CITY OF ALBUQUERQUE

October 17, 2017

**Re: Solar Villa Apts Remodel
Erosion Sediment Control Plan
Engineer's Stamp Date 9-19-17 (J19E086)**

ESC DETAILS

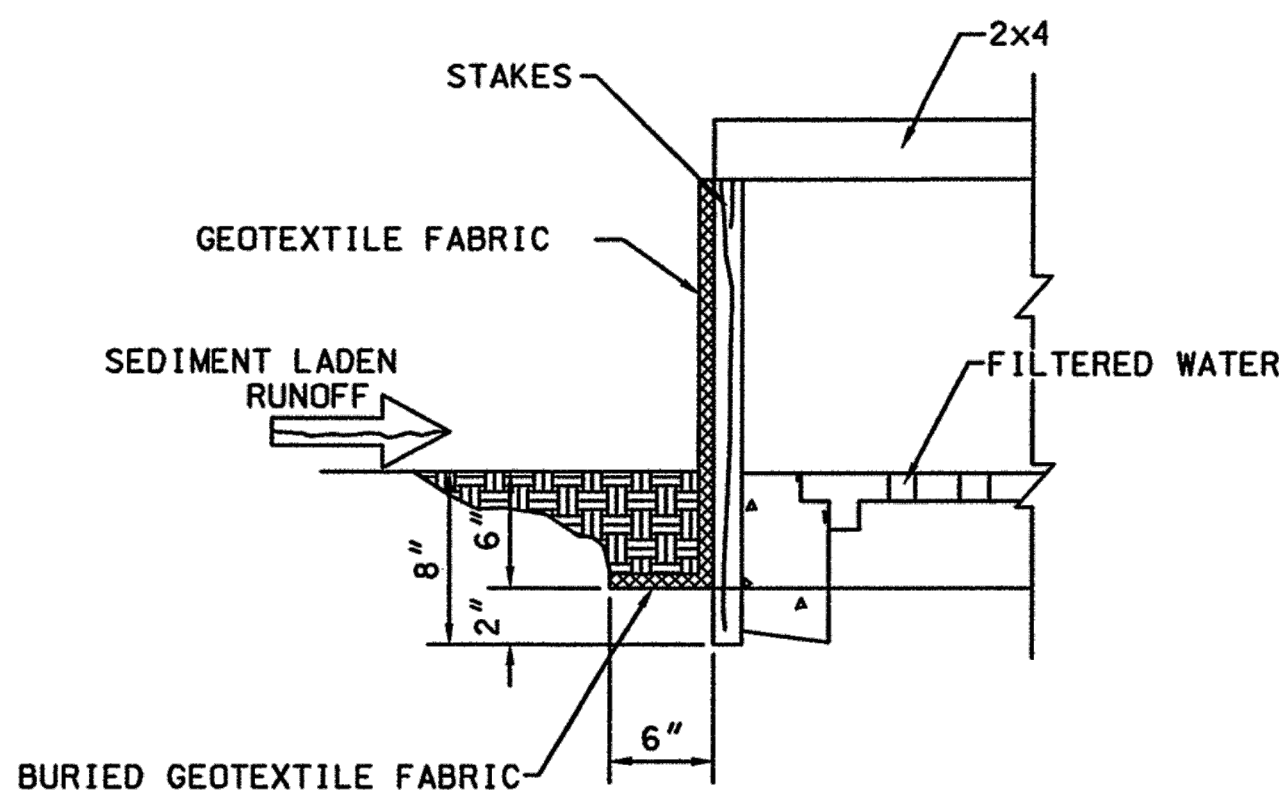
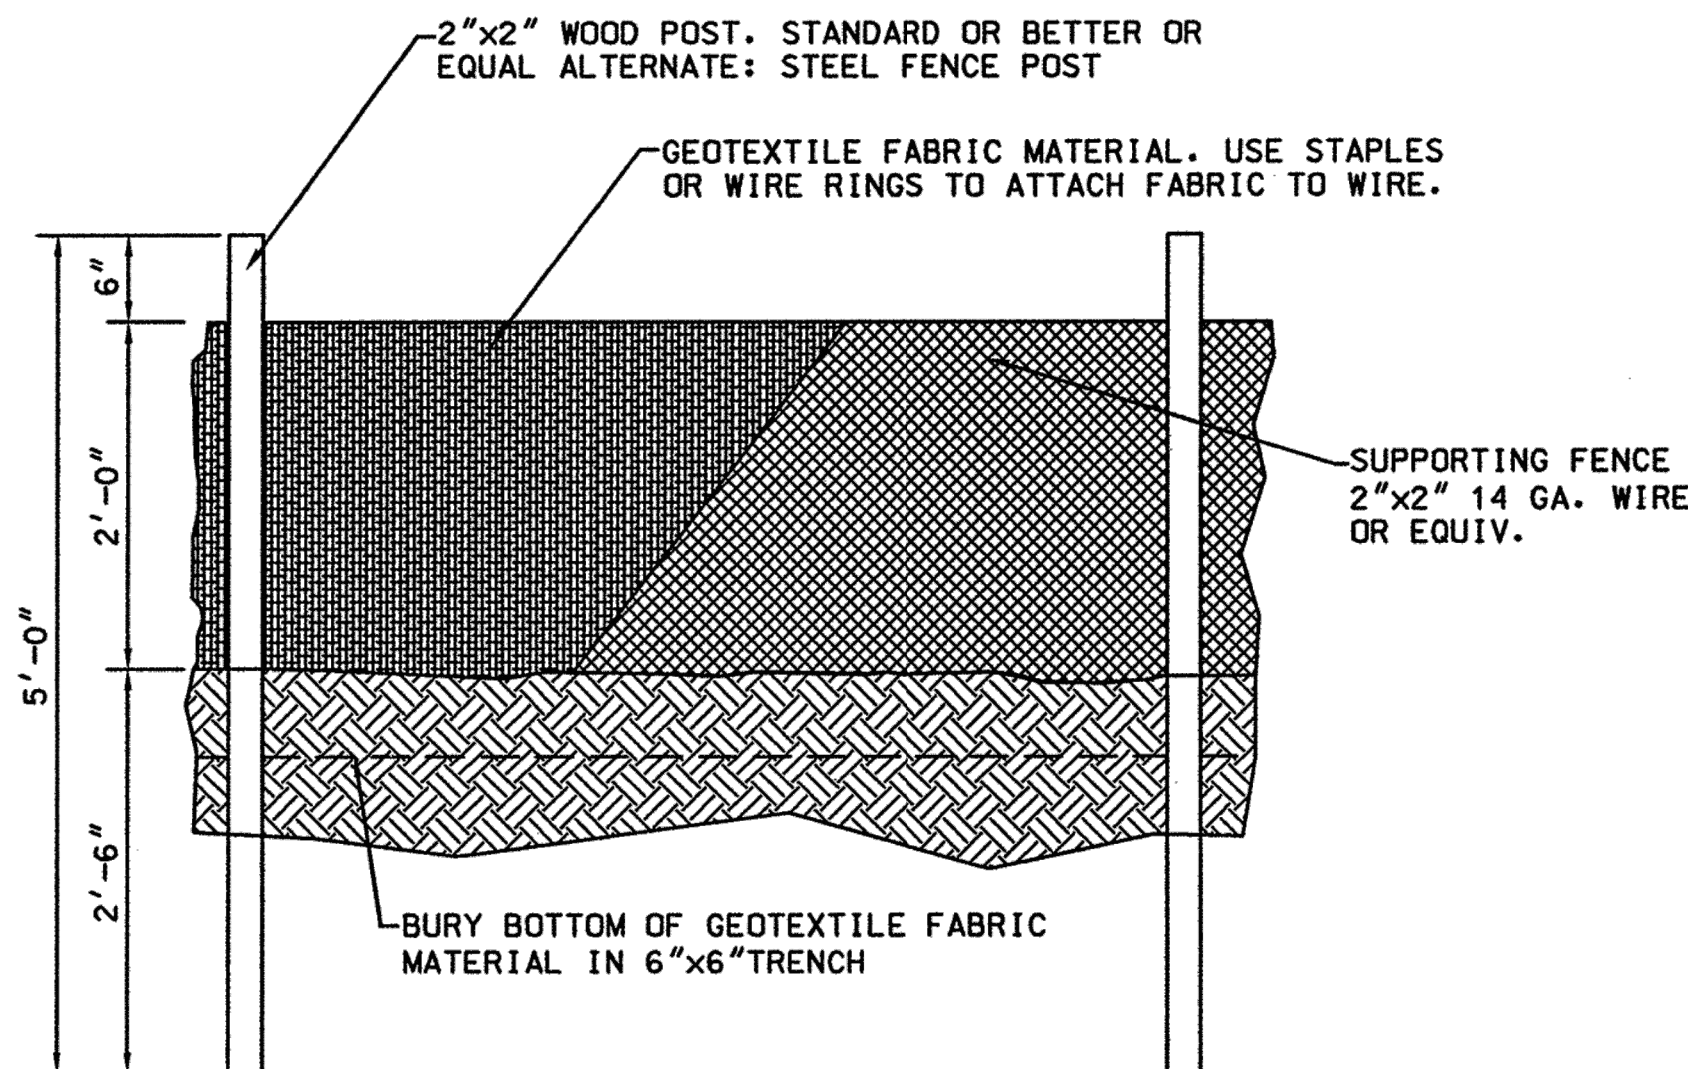
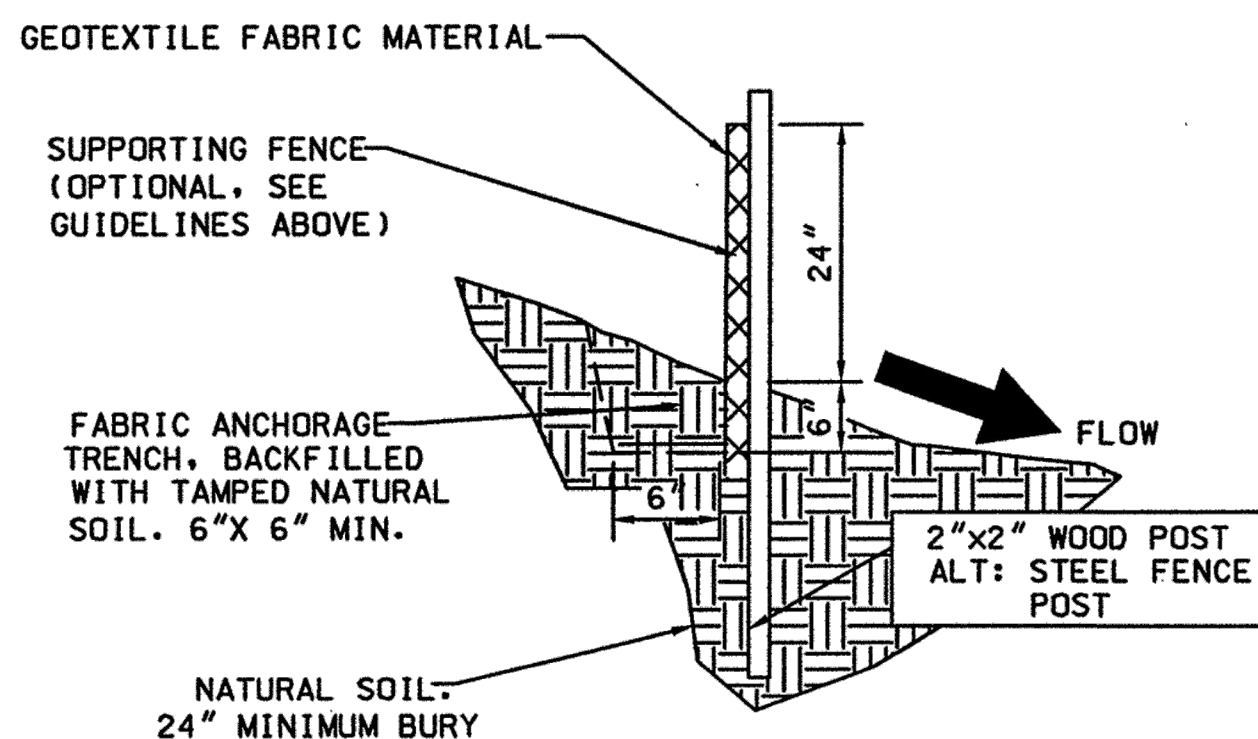
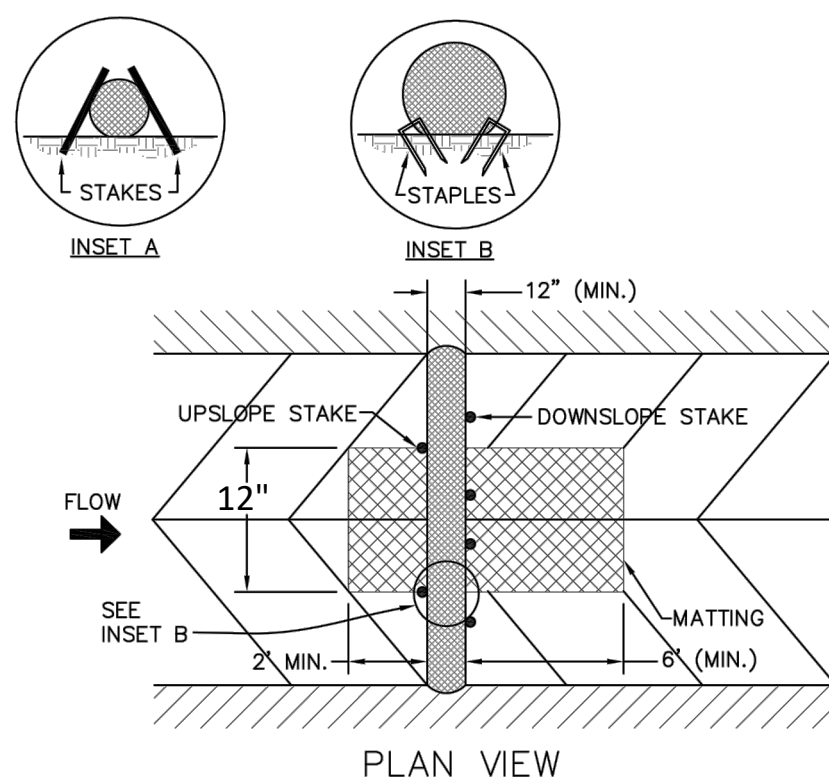
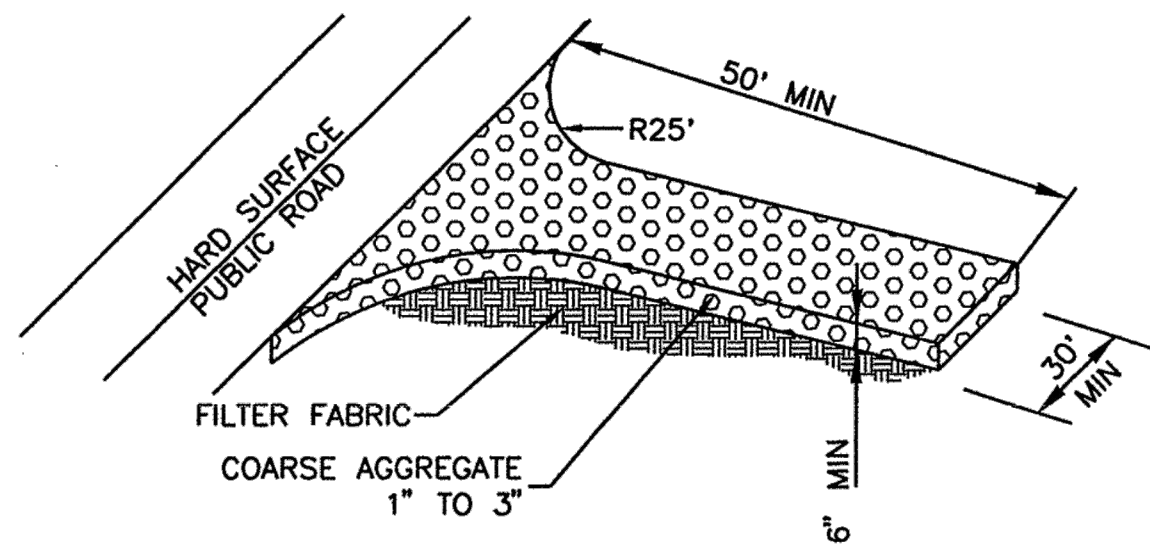
1. There are wood fences along the western and southern boundaries. A sediment BMP is required where the bottom of the wood fence is at ground level. It appears a sediment BMP is required along the western edge at the north end and along the southern boundary.

GRADING AND DRAINAGE PLAN

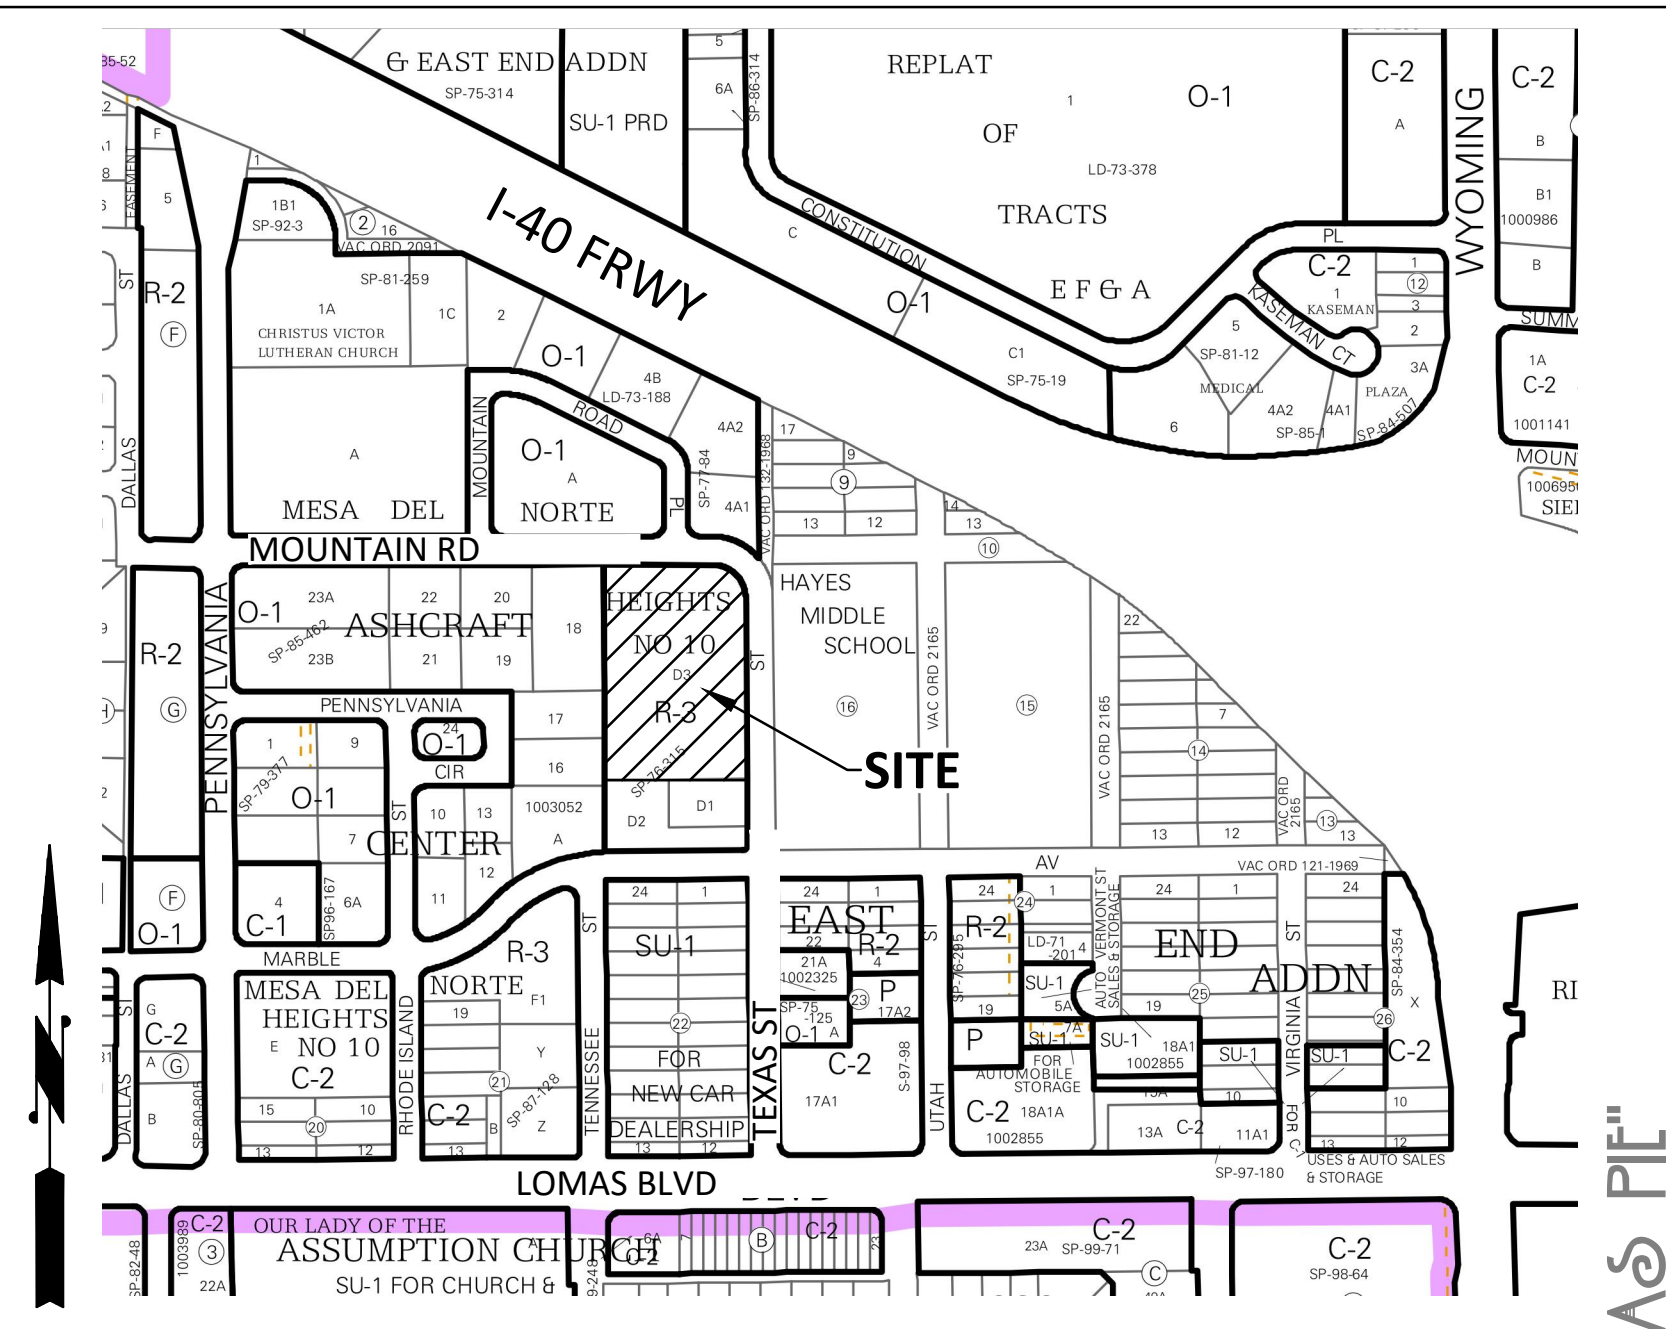
2. Show the stormwater quality ponds that are shown on the grading plan. Ponds are to be graded with initial grading of the site.
